2023/0089

Erection of two storey rear extension and single storey rear porch to dwelling

Water Slack Farm, South Lane, Cawthorne, Barnsley, S75 4EF

Proposed Plans and Elevations

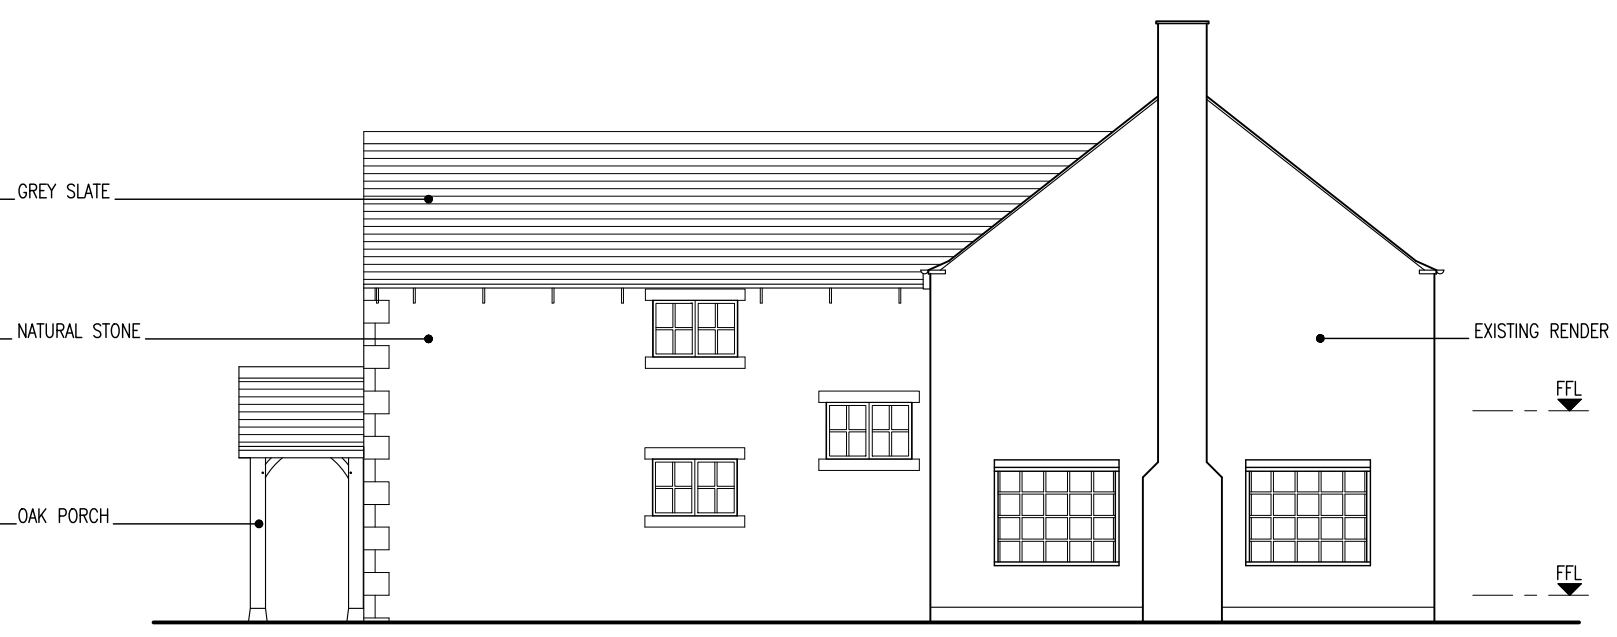
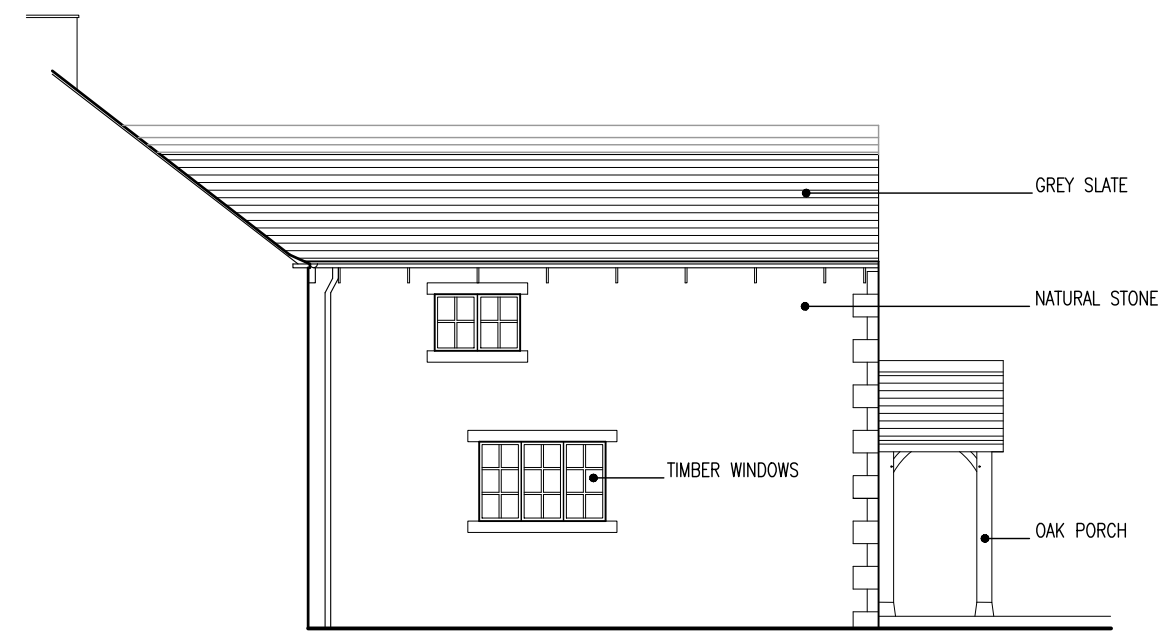
The two-storey rear extension is to be constructed from render with stone quoins to match the original dwelling. The applicant initially intended to construct the extension and clad the existing two storey rearwards projection in natural stone; however, it was considered that the proximity of the varied materials (render, stone, and red brick) would be visually discordant, and amendments were sought.
